Project Name:	Interior Renovation/ Addition	Project ID:	2015-138
Address:	35 Pleasant Street	CBL:	C39 F023001
Applicant:	Lauren Reiter		
Planner:	Shukria Wiar

On April 11, 2016, the Planning Authority approved with conditions a Level II site plan for a building addition to the structure at 35 Pleasant Street. The proposed building addition expands the existing residential use by adding one story to the rear of the building and expands the building over the existing parking area to create a garage and upper floor residential space. This project includes a construction analysis from the construction company outlining how the building expansion to the property lines can be achieved from the applicant's property and will not affect adjoining properties during construction. The applicant has a construction easement along the property boundary for 14 South Street. The decision is based upon the application, documents and plans as submitted by and prepared by Lauren Reiter with a revised date of 03.24.2016. The proposal was reviewed for conformance with the standards of Portland's site plan ordinance.

SITE PLAN REVIEW

Survey & Site Info

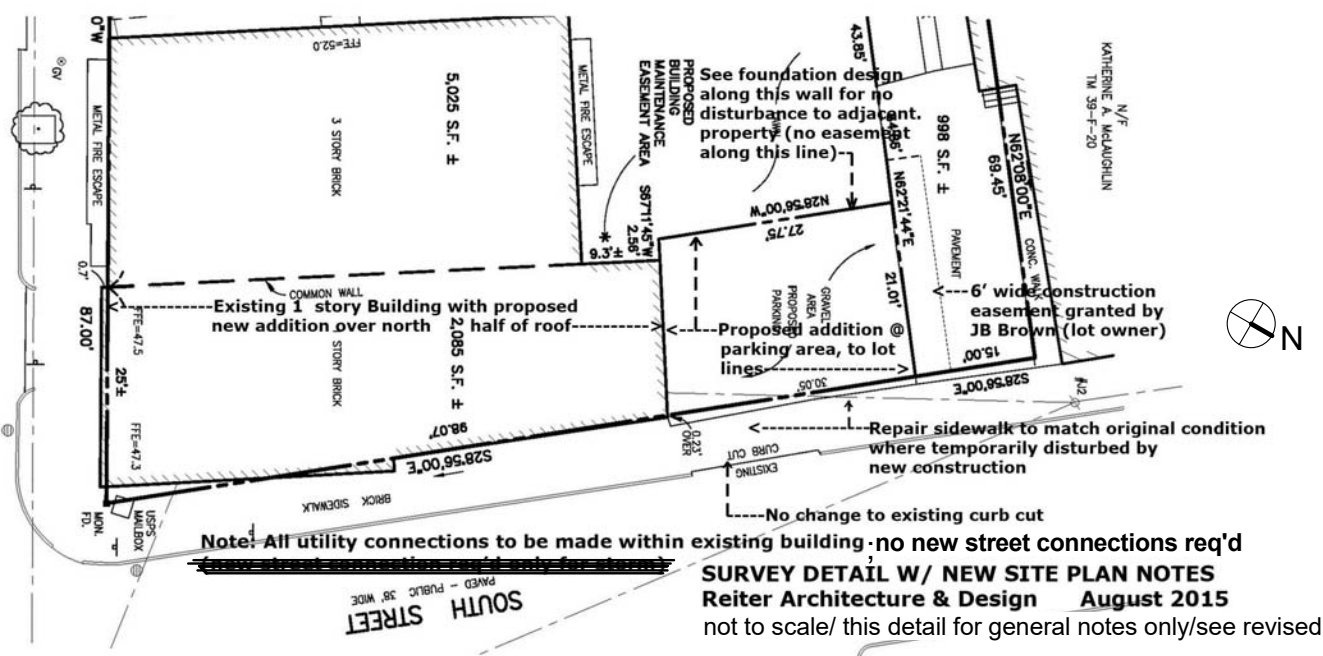
1. The applicant shall cleanly cut any disturbed roots of the Elm tree, on the abutters property at 37 Pleasant Street during construction and be watered if conditions are dry. Deadwood shall be pruned next dormant period as not to attract elm bark beetle to the new wound wood. The applicant shall follow 'best management practices', refer to <http://www.treesaregood.com/treecare/resources/ConstructionDamage.pdf>.
2. Based upon Lauren Reiter's email dated 03.28.2016, the proposed garage will be a two bay garage (the two bays on the southerly side of garage and in line with existing curb cut) for the parking of motor vehicles. The third bay closest to the northerly property line shall not be used for motor vehicle parking space. The doors for the third bay shall not swing onto the City's right-of-way.
3. The site work and general notes #1 and #4 on Plan A101 shall be deleted from the plan.
